File: SF16/25882
Job ID No: DOC16/580846
Your Ref: SSD7689

RE: Heritage Council comments on Walsh Bay Arts Precinct - Stage 2 (SSD 7689)

Figure 65 Render prepared by McGregor Coxall

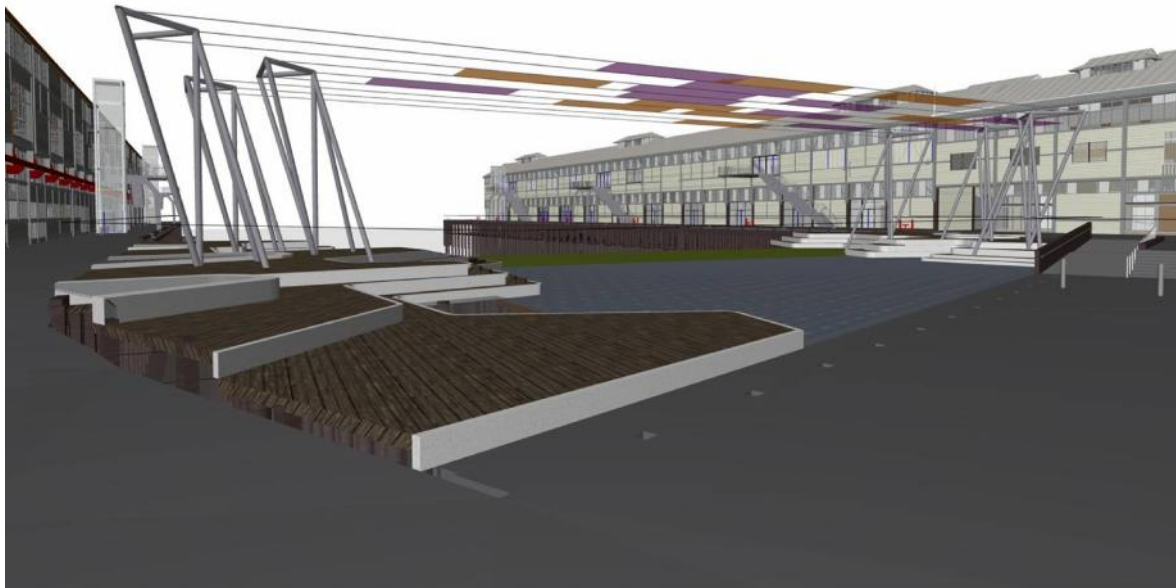
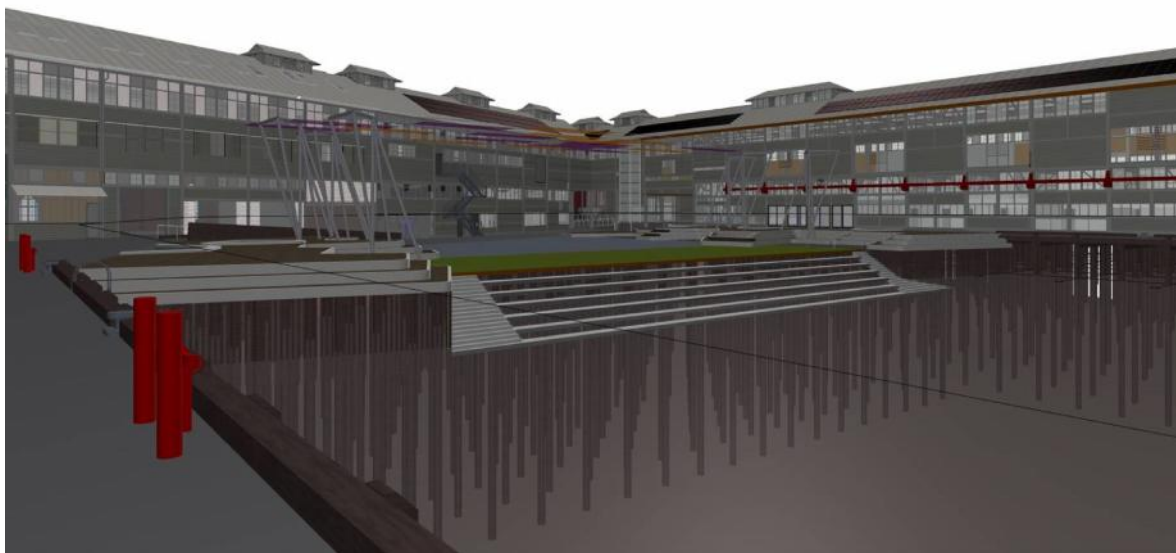
- a) The materials proposed for the Waterfront Square should be reconsidered to remove the grass in favour of more industrial finishes and treatments to respect the integrity of the industrial character of the Walsh Bay Precinct.

- d) Any shading devices additional to the shading structure proposed at the Waterfront Square should be indicated in the drawings for this SSD. Shading must be considered at this stage
